Our ref: Residential flat building with in-fill affordable housing – 5–9 Cowan Road, St Ives (SSD-88948458)

27 November 2025

Subject: Response to Submissions

ATTACHMENT A – ITEMS TO BE ADDRESSED

1 Previous GFA Diagram - Ground Floor Plan

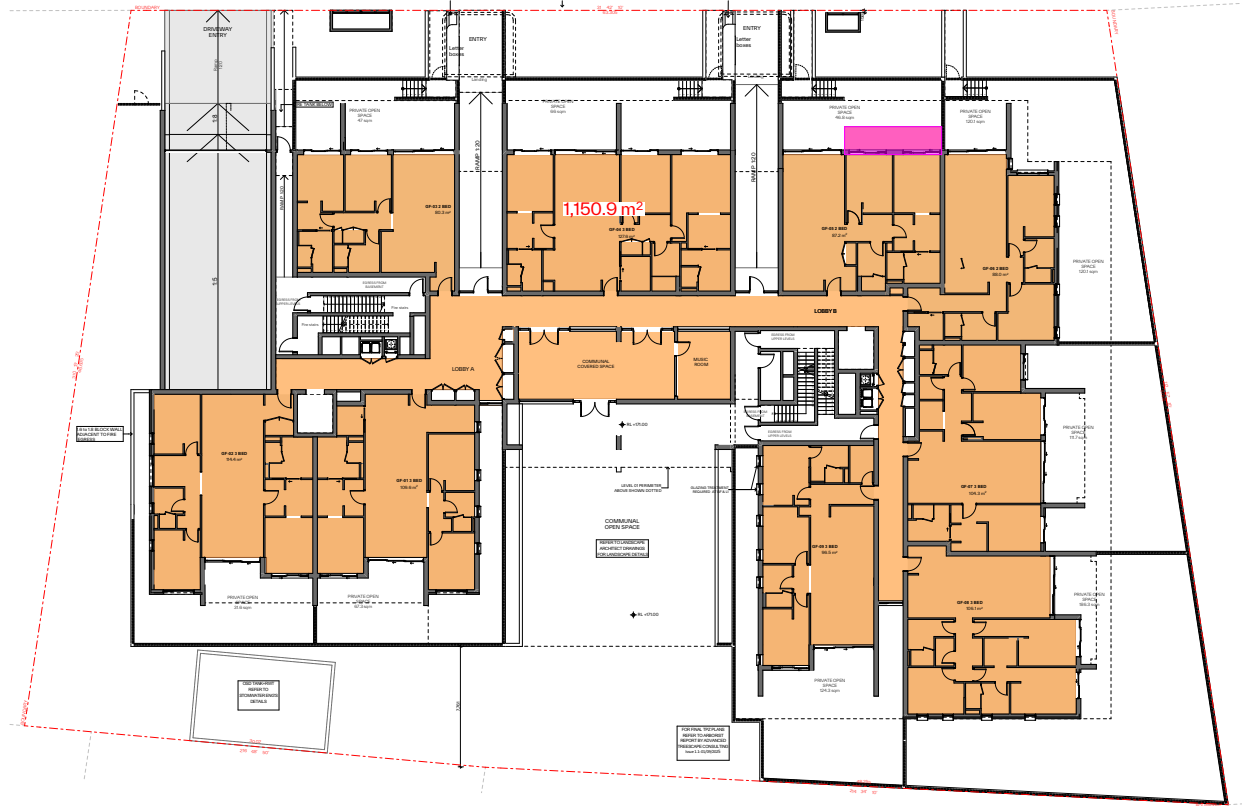
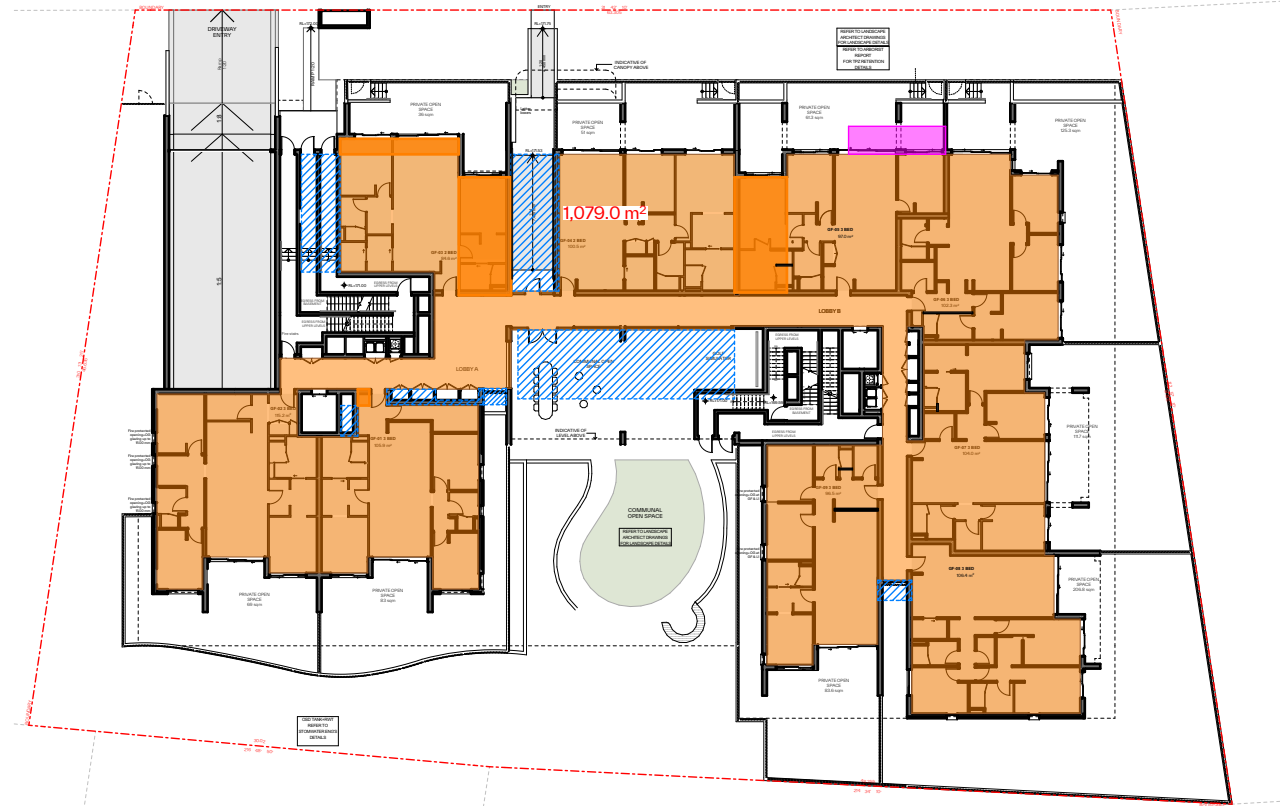
4. Review the GFA calculation plan, noting 14.9% of the overall GFA appears to be dedicated to affordable housing GFA rather than the required 15% and some areas appear to be incorrectly calculated, including:
 - the external area to GF-05
 - the voids to level 9 (DA110).

COMMUNAL OPEN SPACE

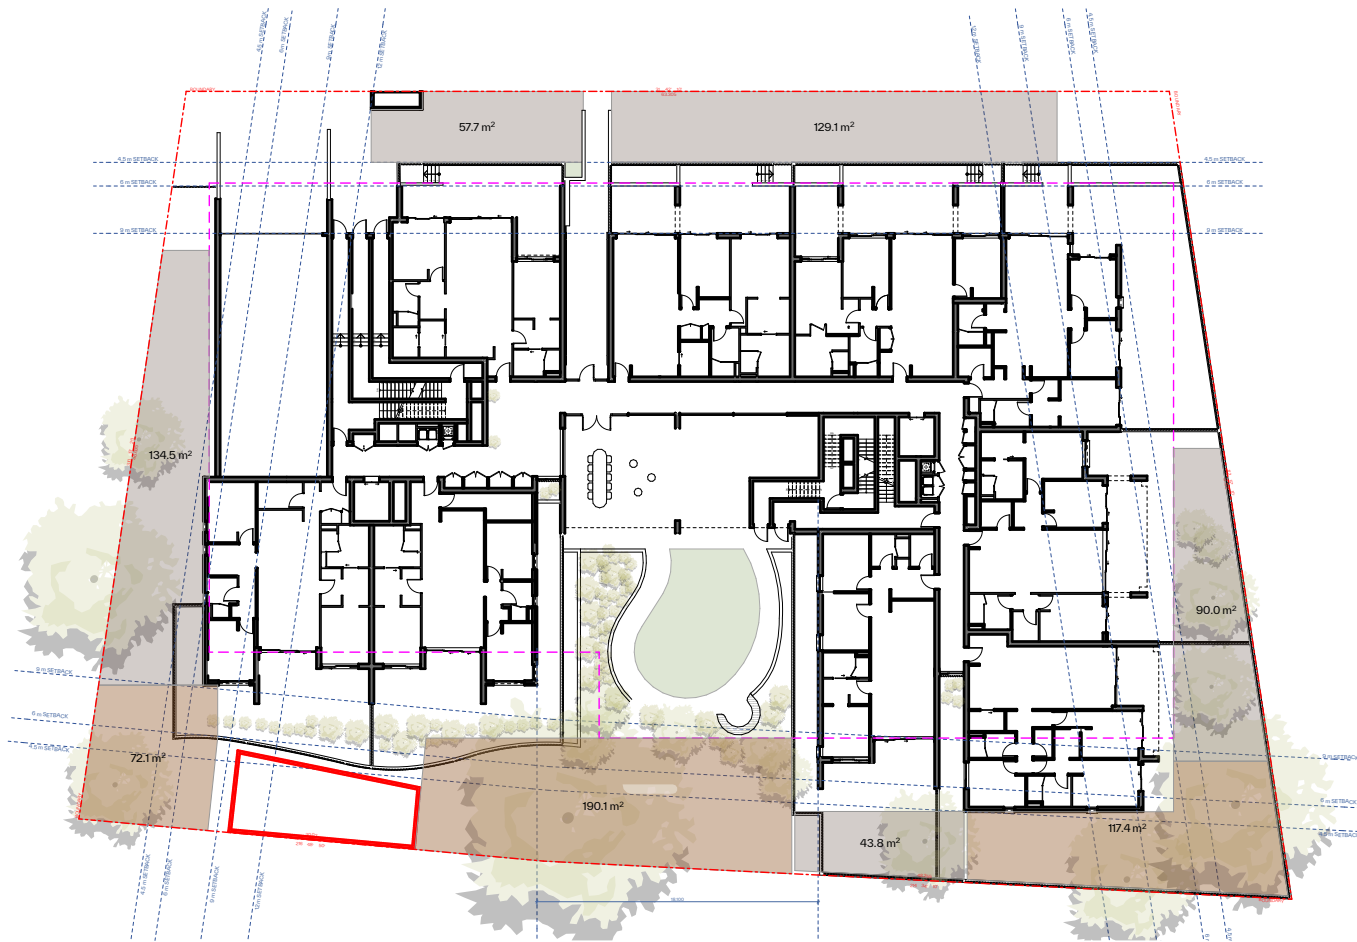
15. Revise the level 8 communal open space calculation plan (DA540) as it has included the area beyond the balustrading, which is not accessible.
16. Revise the deep soil calculation plan to show dimensions of 6 m and an area of no less than 7% of the site area as per the design criteria contained in part 3E of the ADG.
17. Revise the landscaped area calculation plan to exclude any footpaths or other hard surfaced areas, as this is not counted as landscaped area.
18. Revise the ground floor architectural plans against the landscape plan, as there is inconsistency between the location of paving, decking and landscaped area.
